Planning and Regulatory. G.Mansfield
Reference: PB2015/00161
Phone: 02 4974 2767

28 October 2015

NOTIFICATION OF MODIFICATION REQUEST NEWCASTLE PRIVATE HOSPITAL -2 &14 LOOKOUT ROAD NEW LAMBTON HEIGHTS

I refer to the Department's letter of 2 October 2015 advising that Healthscope Operations Pty Ltd has submitted a request (08_0170 MOD 2) to further modify the approval granted in 2009 for the Newcastle Private Hospital Project.

**PROPOSED GROUND FLOOR PARKING**

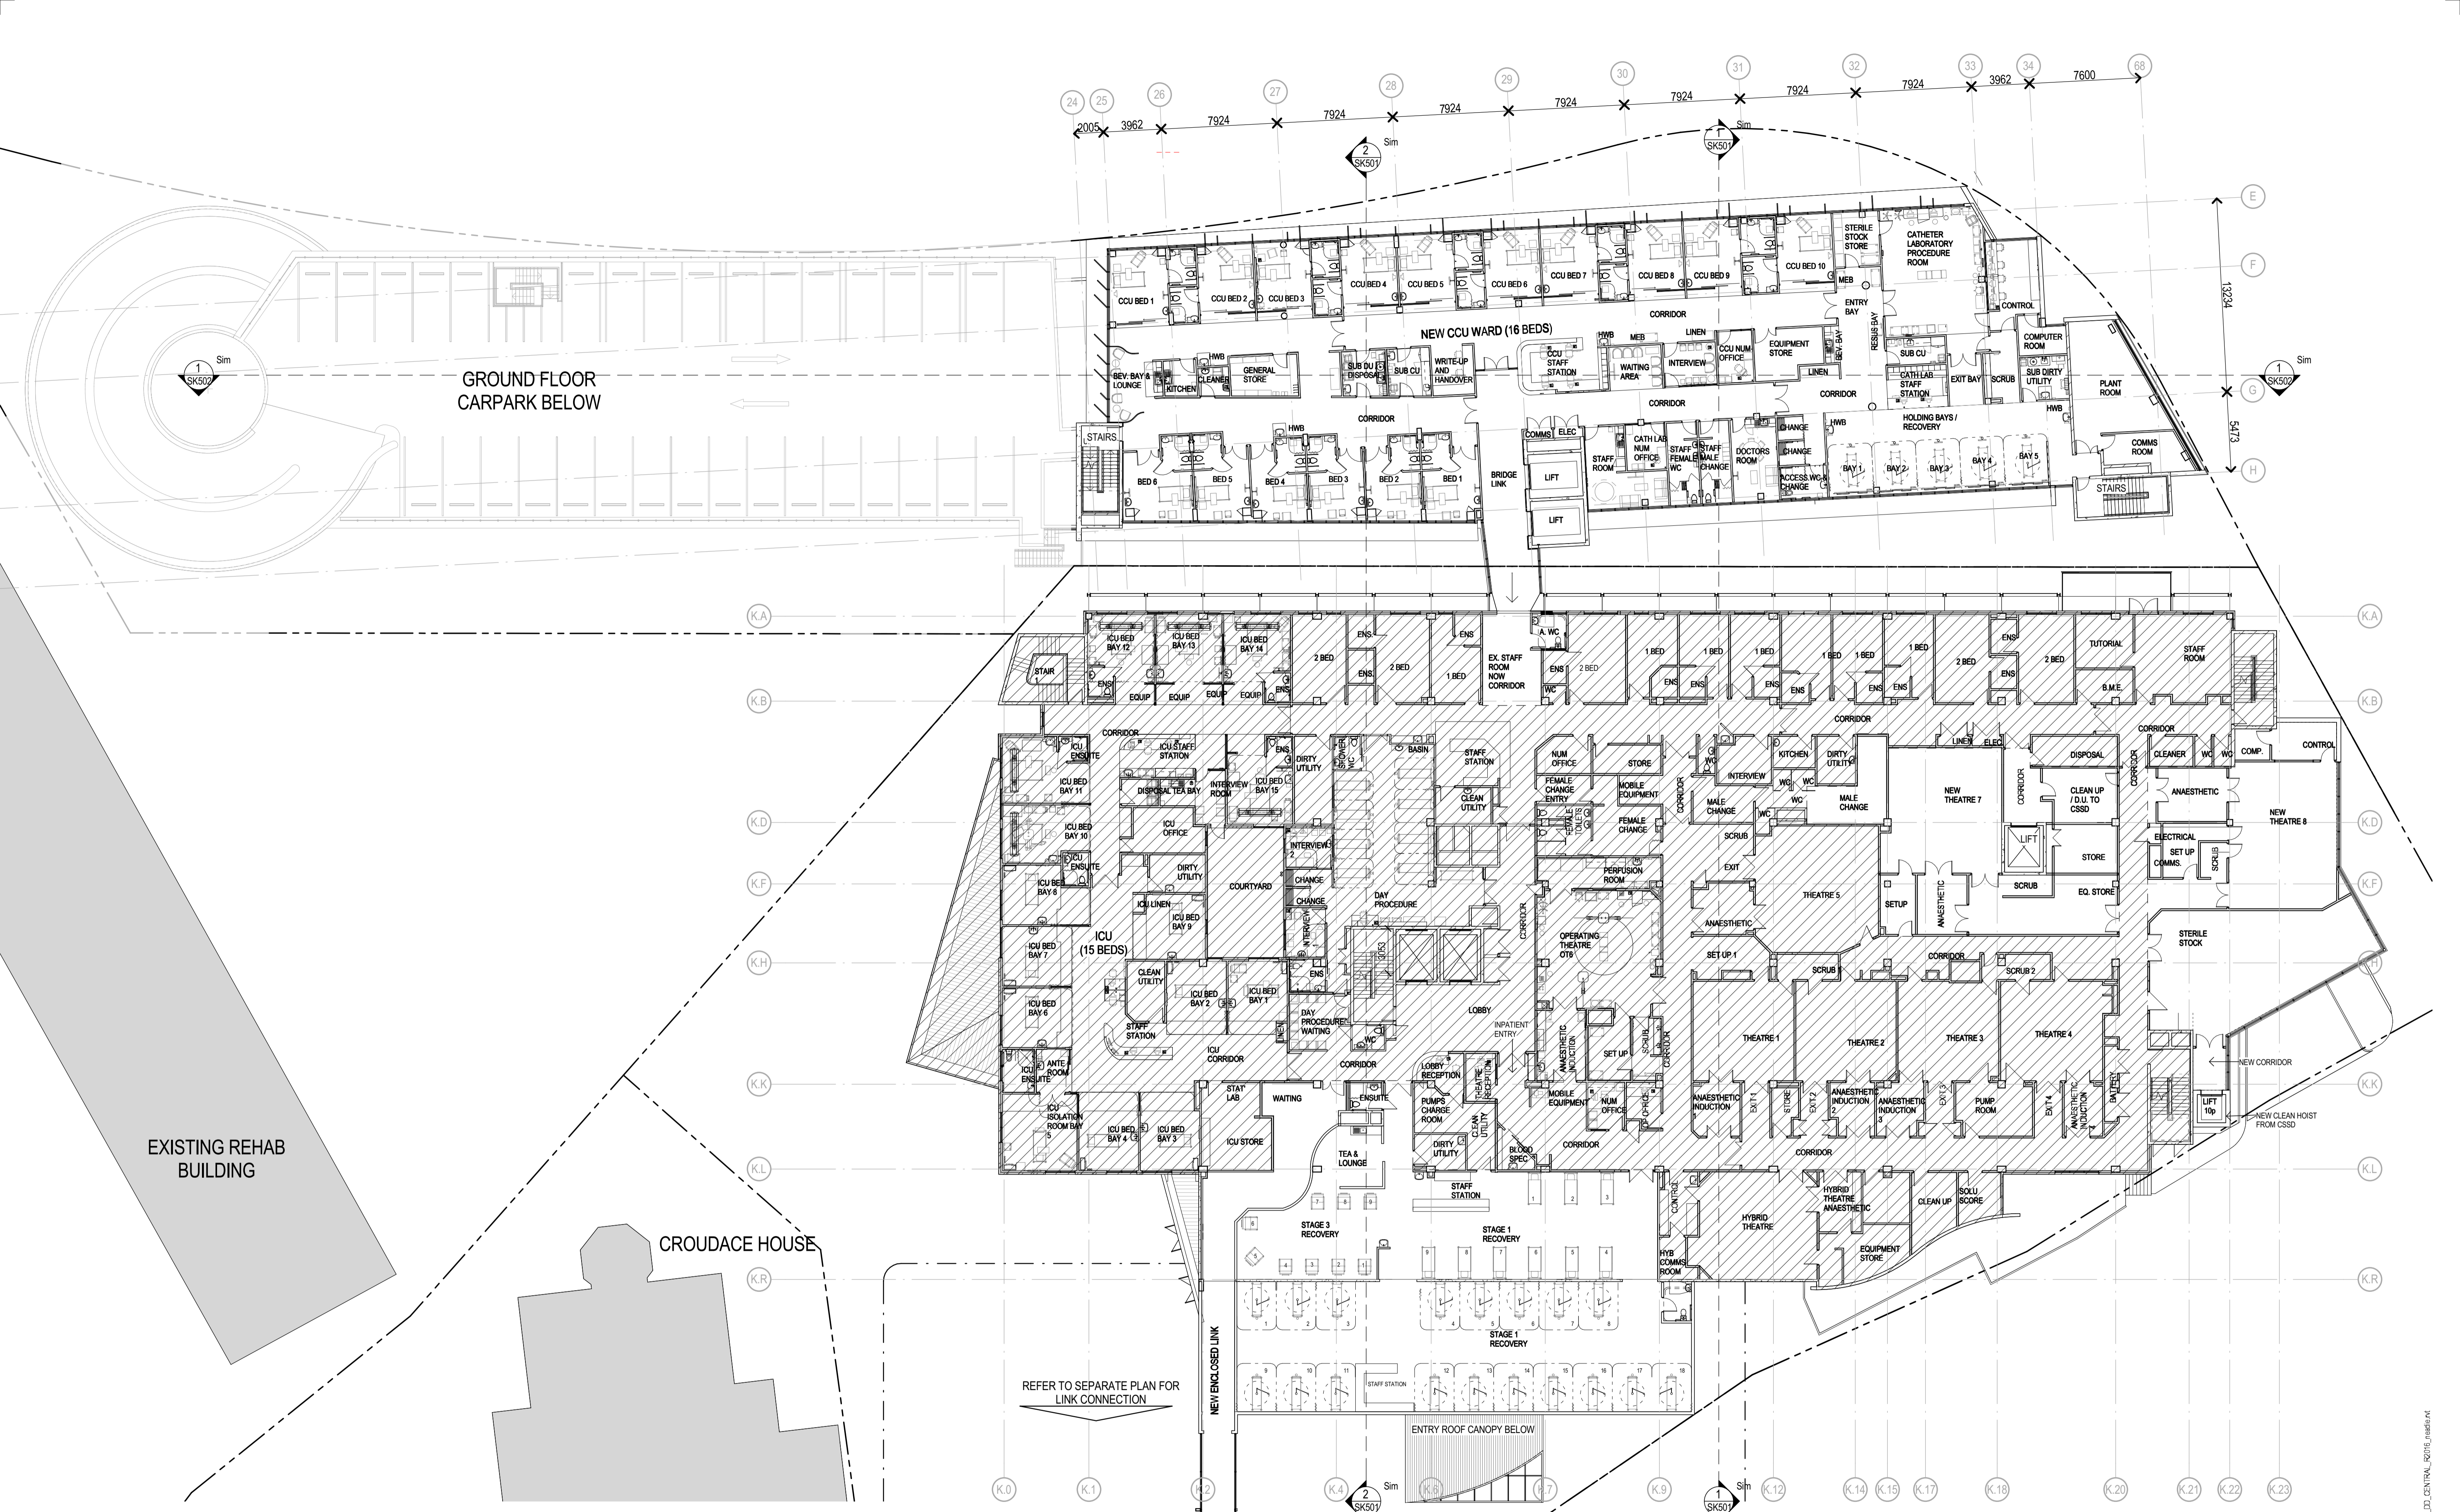
To minimise the potential for vehicular/pedestrian conflict it is recommended the design of the modified project be amended to include a designated pedestrian pathway within the new at-grade car park between bays No. 5 to 14 and 24 to 31 linking to the 'Kingston' and 'Croudace' buildings

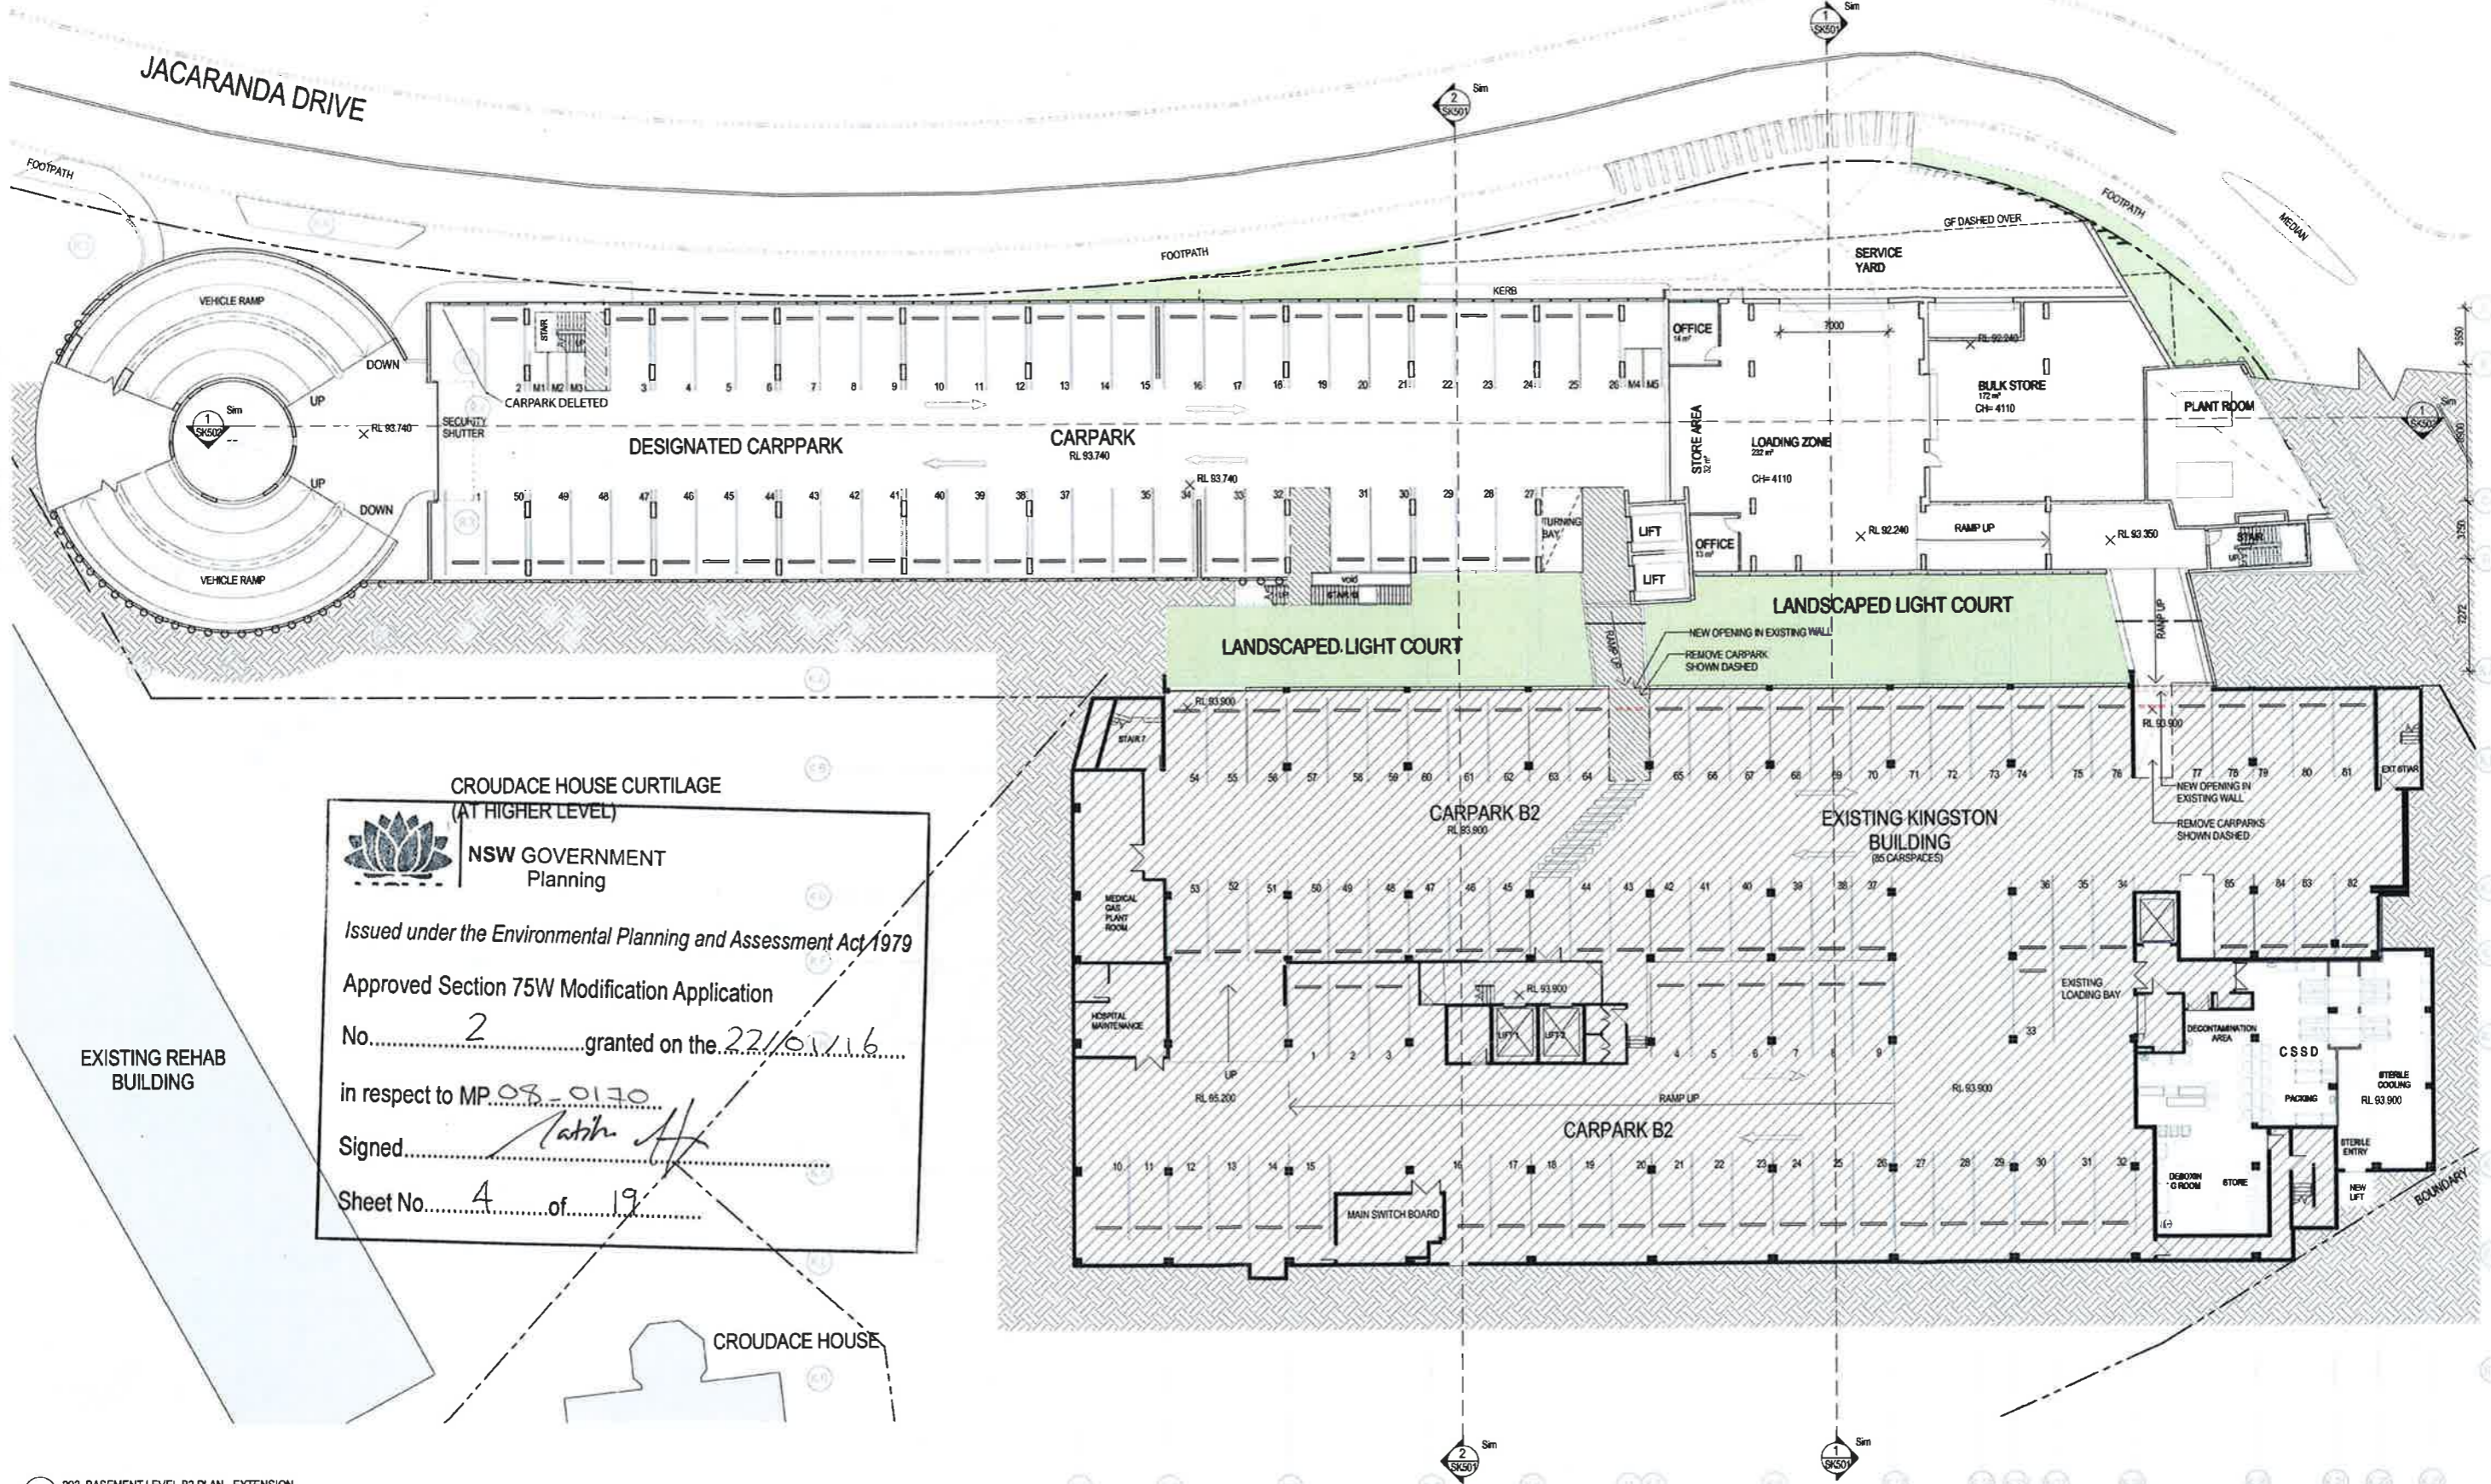
Council's previous submission of 24 July, 2009 raised safety concerns in the relation to the proximity of proposed parking spaces to the access ramps at each level in the parking station. Driver sight lines are considered to be compromised thereby

increasing the potential for vehicle conflict. This issue has not been addressed by the traffic consultant's report and needs to be reviewed and resolved prior to the determination of the modification request.
